WEST SUSSEX COUNTY COUNCIL CONSULTATION

TO:	Arun District Council FAO: Mrs A Gardner
FROM:	Highways, WSCC
DATE:	01/02/2019
LOCATION:	55, Sea Lane Gardens, Ferring, BN12 5EG
SUBJECT:	FG/11/19/DOC Application to discharge condition 4 (landscaping) and 9 (Construction Management Plan) in relation to planning application FG/94/18/PL.
DATE OF SITE VISIT:	N/A
RECOMMENDATION:	☒ Advice ☐ Objection ☐ Modification ☐ No Objection ☐ More Information ☐ Refusal
S106 CONTRIBUTION TOTAL:	£N/A See below for breakdown.

55 Sea Lane gardens CMP

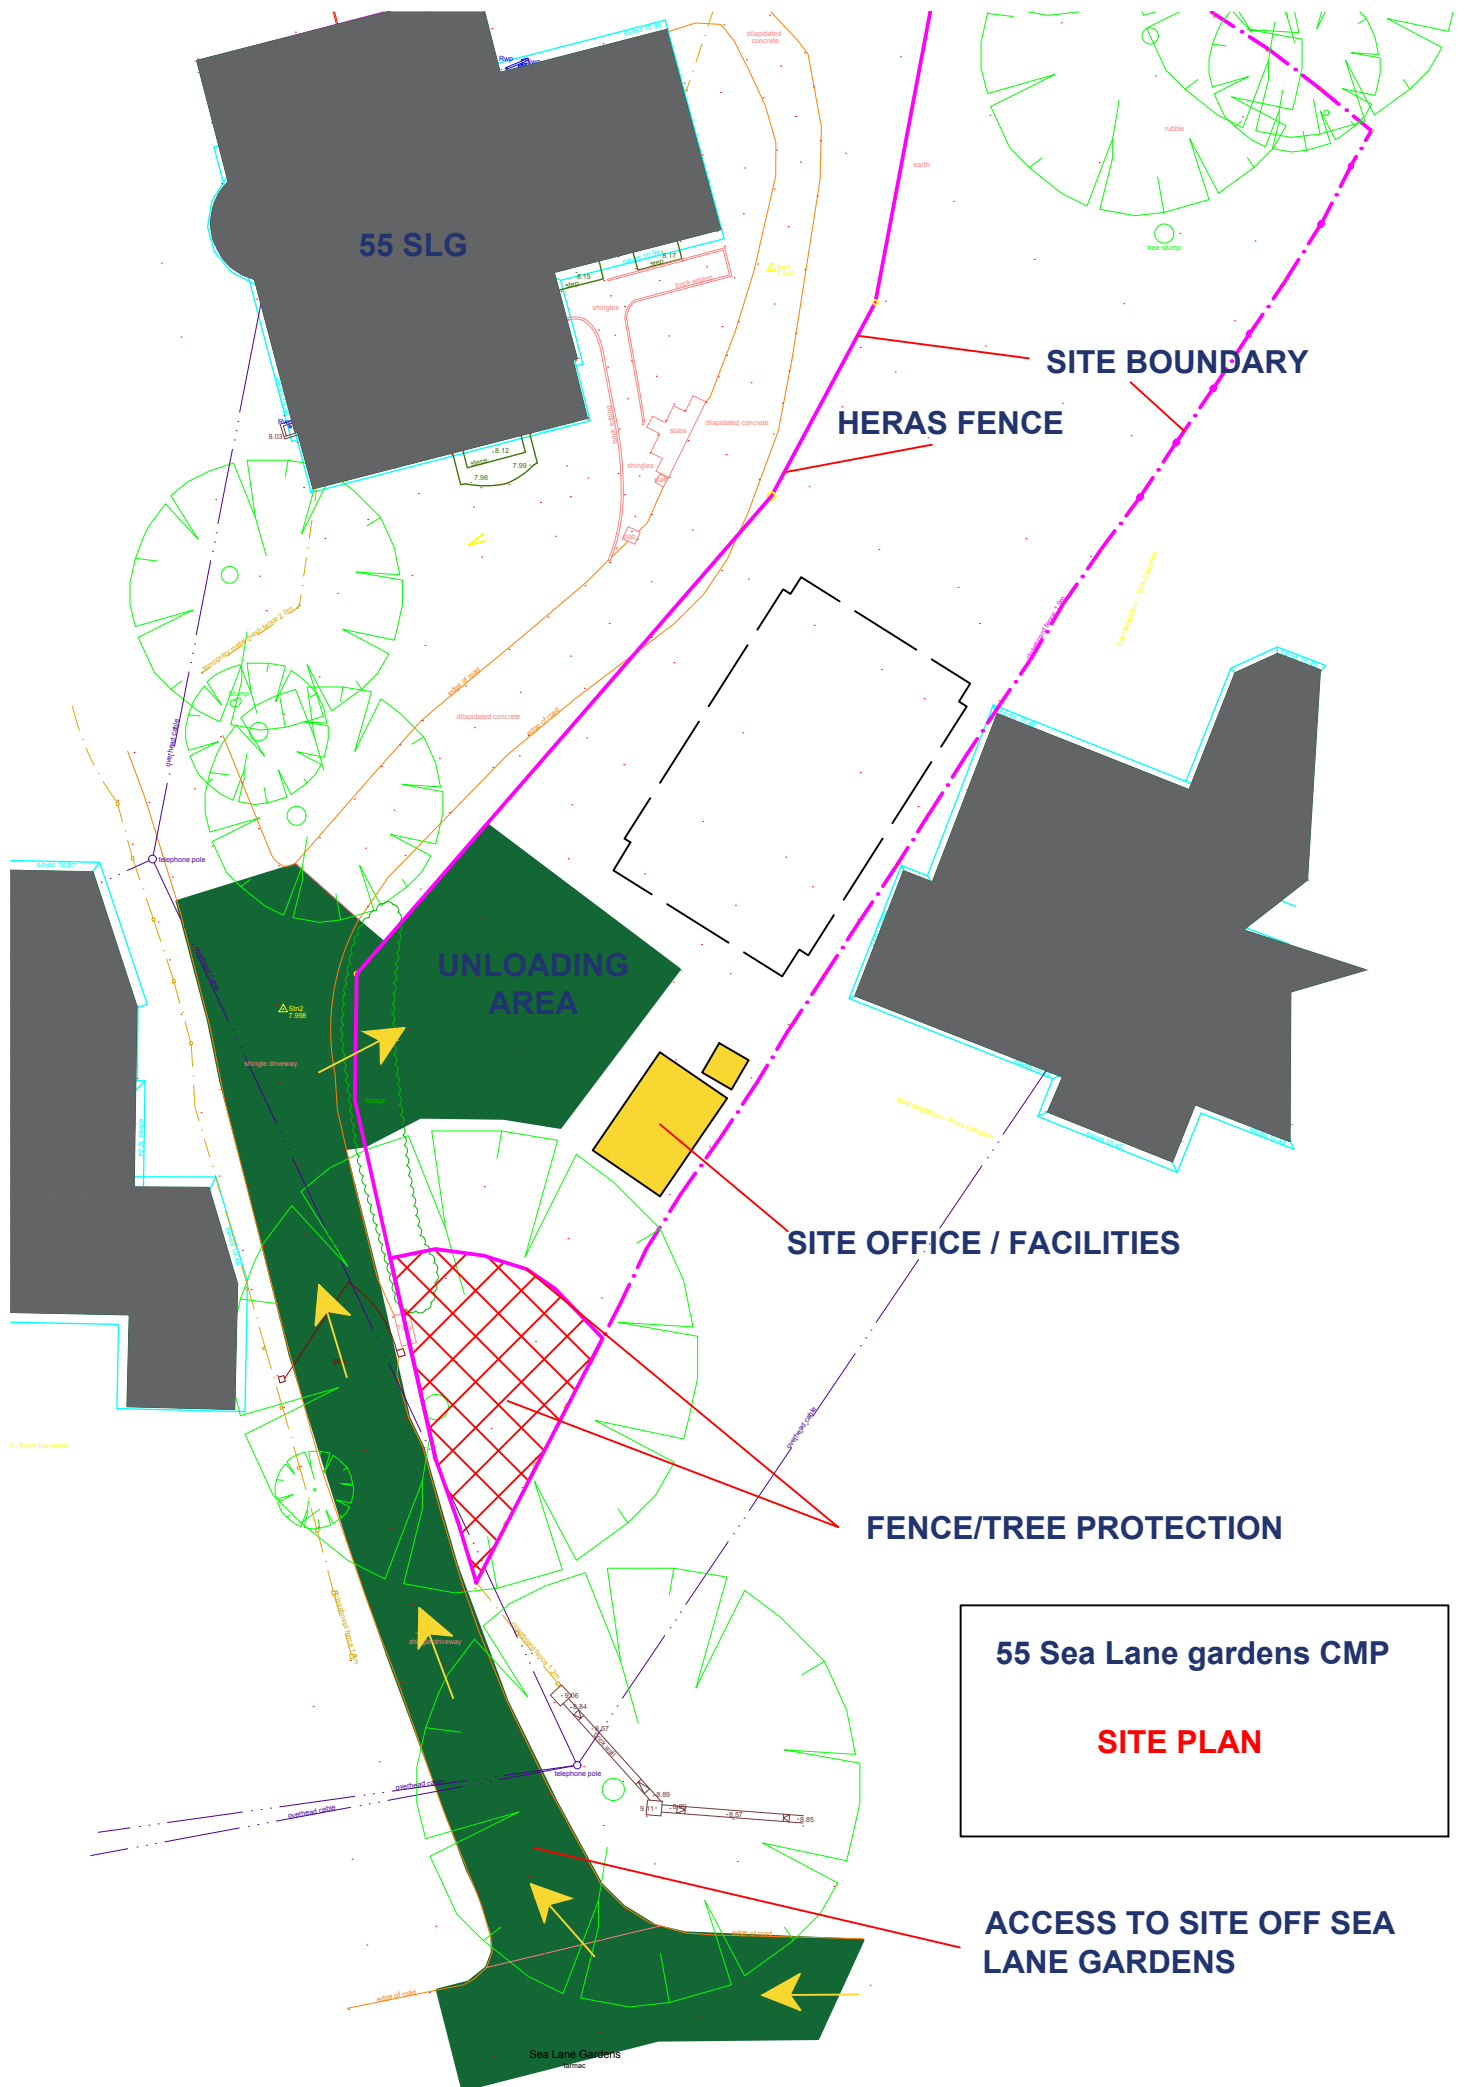
The LHA note that the applicant intends to specify maximum vehicle sizes for the deliveries. This will ensure that appropriately sized vehicles are travelling to the site and would be able to turn to exit onto the public highway in a forward gear. Confirmation of delivery arrival before accessing the site will also aid in reducing congestion associated with the site.

The LHA would not anticipate the proposal to cause a 'severe' impact on the public highway and therefore would not be opposed to the dismissal of condition 9.
